SPR EA1N and EA2 PROJECTS

DEADLINE 9 – COMMENTS ON DEADLINE 8 FLOOD RISK SUBMISSIONS

Interested Party: SASES **PINS Refs:** 20024106 & 20024110

Flood Risk related responses to Deadline 8 submissions on Scottish Power Renewables proposed EA1N and EA2 onshore works near Friston

Rev	Date	By	Comment	Approved:	FM				Figure	2

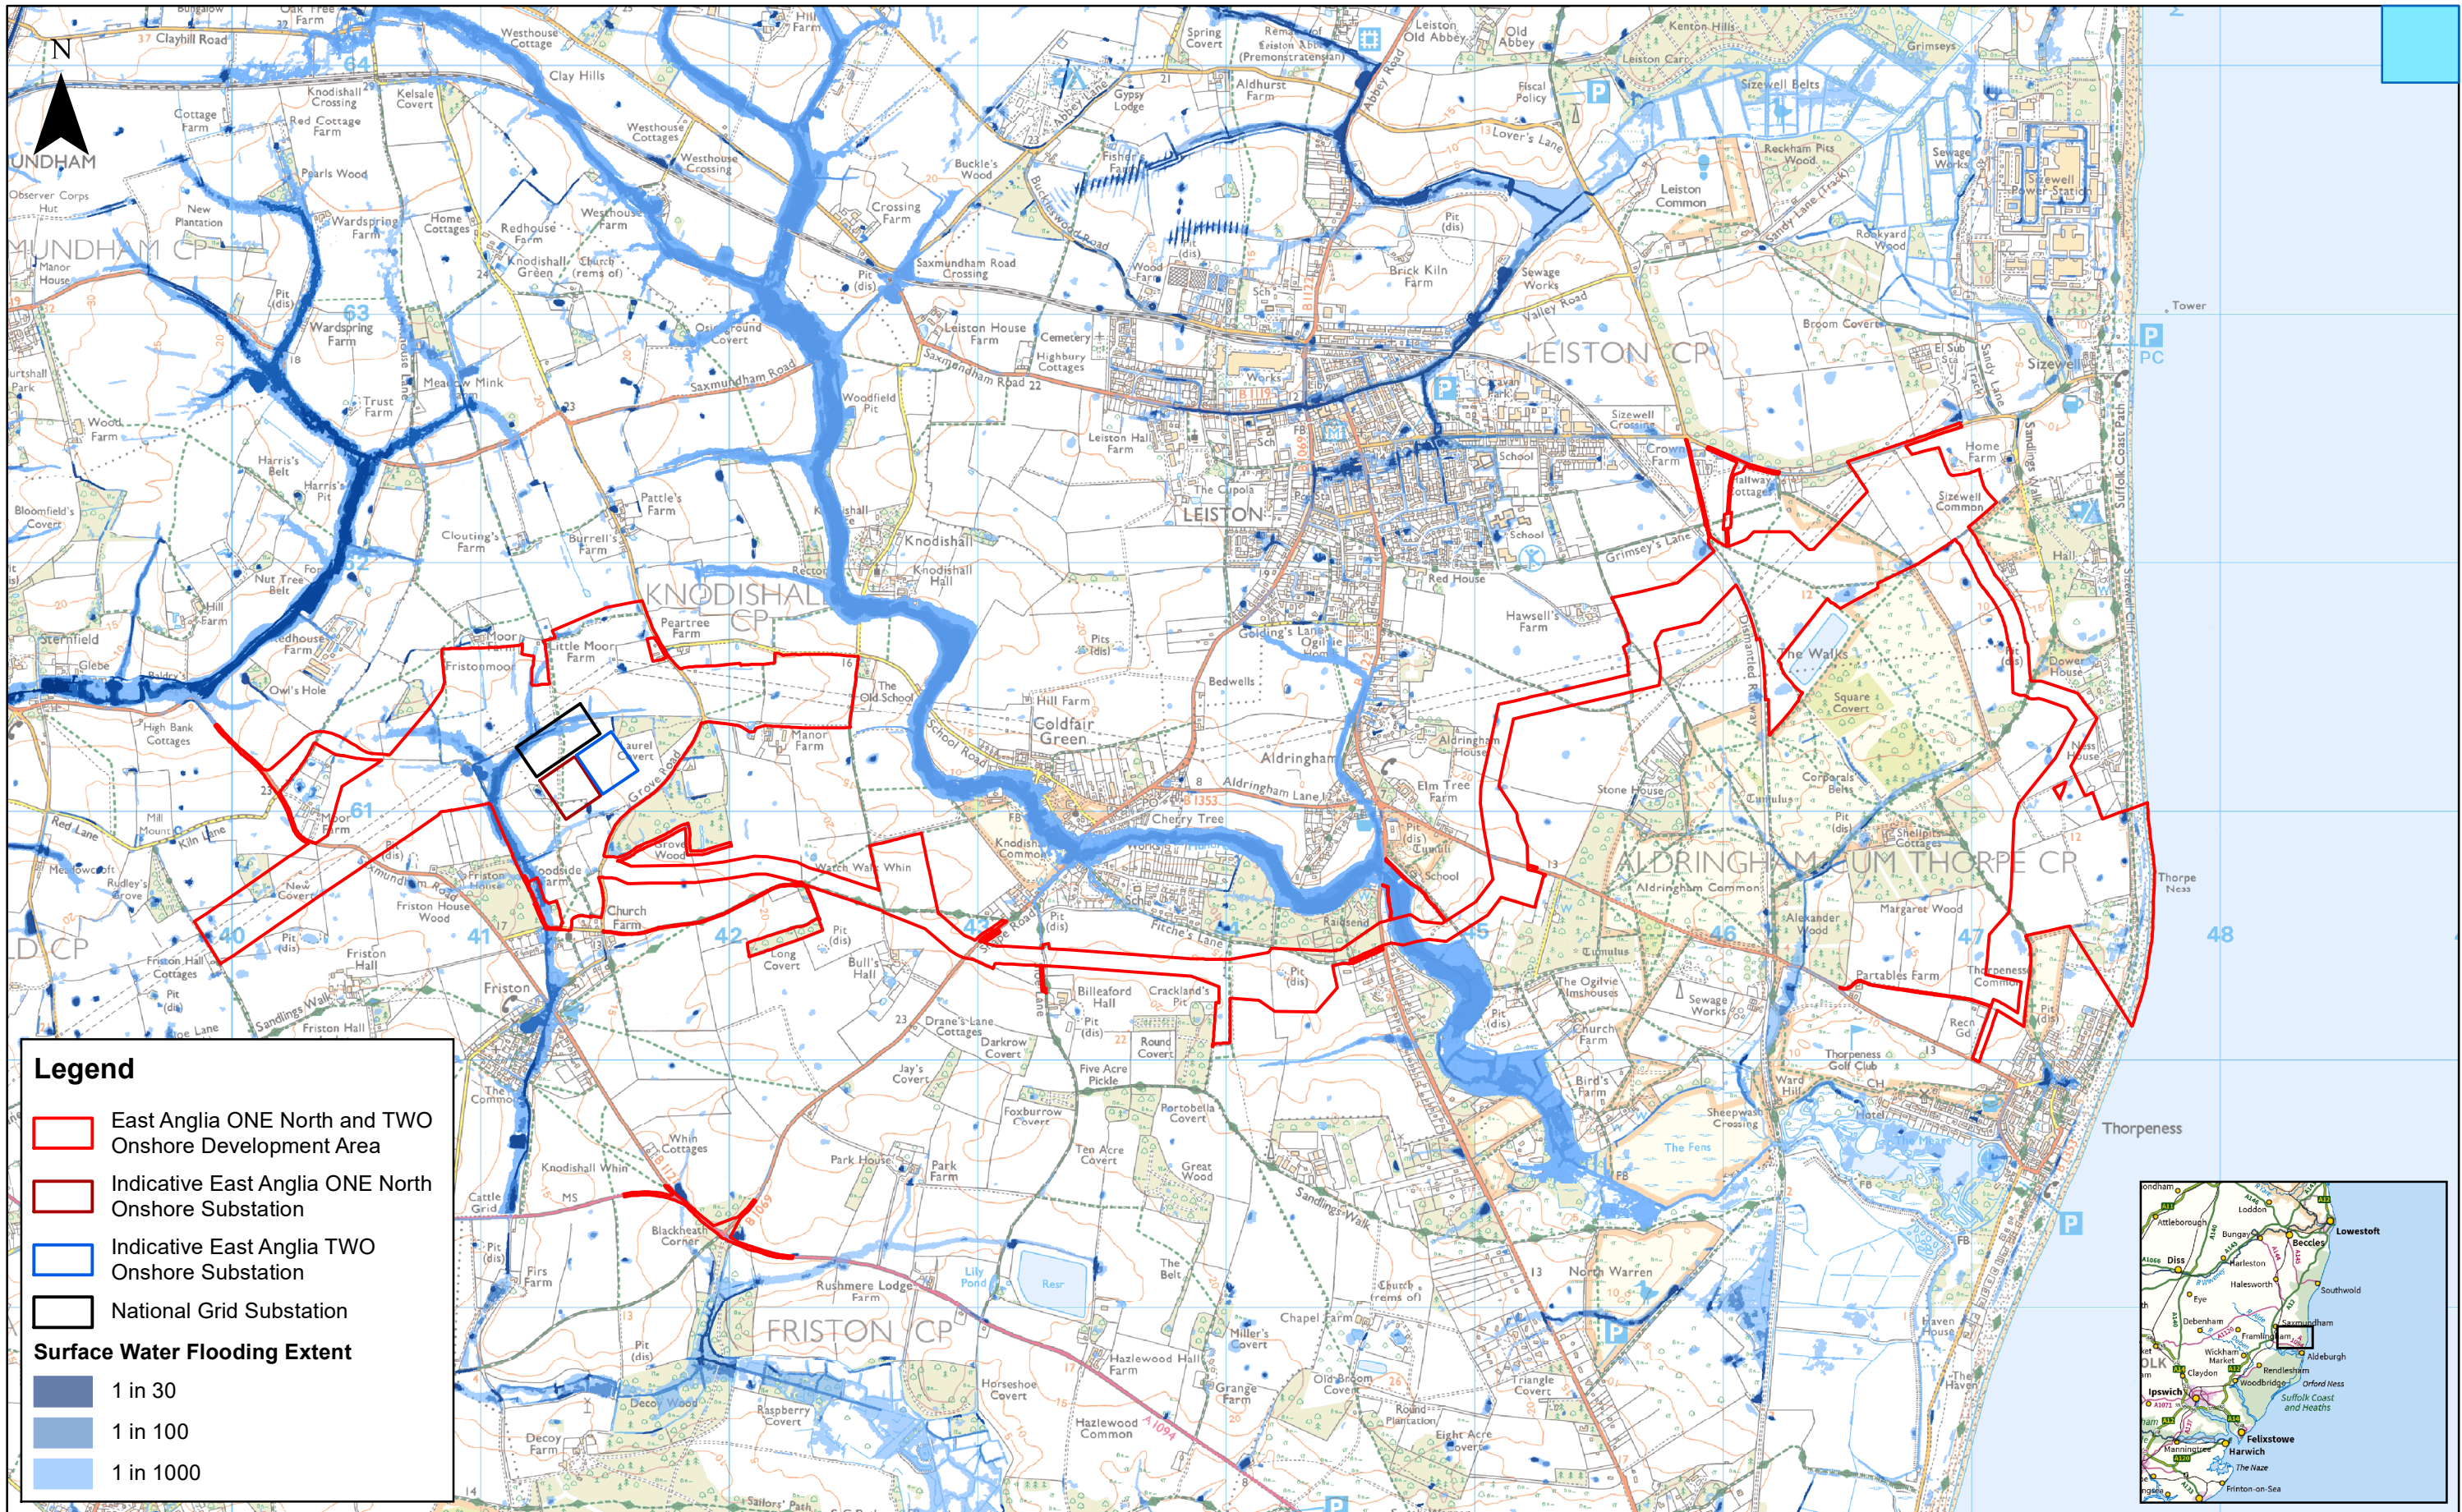
The main update to the OODMP by the Applicant is the addition of a third 'hybrid' drainage option, to the Infiltration Only option and Surface Water Discharge Only option provided before in earlier submissions. The Hybrid option is proposed by the Applicant because the Infiltration Only option cannot be demonstrated by them to be viable, and SCC refuses to accept the Surface Water Discharge Only option.

The Hybrid option (there are two hybrid basins proposed) proposes a single basin which allows water to infiltrate the ground through the base of the basin. Once the water depth in the basin reached 0.5m depth then it will start to overflow out of the basin at QBAR. Water levels in the basin will rise up to 1.5m depth.

GWP contend that whilst the Hybrid design does allow for infiltration and surface water discharge, the infiltration component is relatively minor, with effectively all water above 0.5m depth actually then flowing out of the basin to the surface water course. This design is NOT optimised to maximise infiltration, it is optimised to ensure it will fit within the site. The Applicant does not provide details of the flow hydrographs or volumes to enable comparison of the % of the flows which infiltrate into the ground compared to those which are discharged to the surface water course. It is therefore not possible to compare whether the TOTAL flow is more or less than the baseline scenario, which is a critical issue given uncertainty over both the QBAR estimate, and whether QBAR causes flooding in Friston. If the Infiltration Basin was to maximise infiltration it would be designed to fill completely and then overflow (via a controlled mechanism) to a secondary attenuation pond for discharge to surface water. This current design self-evidently stores a much greater volume of run-off above the surface water discharge outlet pipe than below it.

The proposed Hybrid design does not meet the objectives of the stated SCC SUDS hierarchy requirements nor have the design parameters been demonstrated to be accurate. The design itself therefore has not been proven to be viable.

Notwithstanding the points raised above: the proposed storage design will retain 1.5m depth of water - which breaches SCC requirements; its design volume is <2% more than the required volume – which is unacceptably small and does not allow for design parameter inaccuracy or performance inefficiencies eg blockages; and the total storage including freeboard and landscaping is with 10% of the Reservoir Act, despite being immediately above a residential village and the design is without consideration of overflow structures, which is unacceptable.

The last update to the OODMP is an outline drawing of the outfall pipe from one of the storm water attenuation basins and its discharge into the Friston watercourse. The outlet pipe is proposed to be located along the farm track and discharge into a box culvert under the road before entering the existing ditch system passing through the village.

No dimensions or design details are provided to enable estimate of cover depth or material strength, nor details of traffic or vehicle loading assessment provided, especially for the pipeline section beneath the farm track. It is not therefore possible to comment on the structural integrity of the proposed design with respect to damage from vehicle loading.

The design does however appear to have failed to consider the farm track IS the watercourse north of the road and therefore is subject to storm erosion, sedimentation and flow inundation. The box culvert into which the pipe has an open-ended outlet will therefore during operating conditions be receiving turbid run-off water from the surrounding fields and is highly likely to be both full of water constrained by the current downstream ditch geometry and routinely filled or partially filled with sediment. The outlet pipe located as it is on the floor of the box culvert is highly likely to become blocked with time and its conveyance restricted. This appears to not have been considered. Clearly the consequence of a partially or fully blocked outlet pipe is water backing up in the basins and potentially overtopping the basin bunds. The design appears highly likely to become blocked and is considered unreliable.

There are no details provided of the outfall from the second basin.
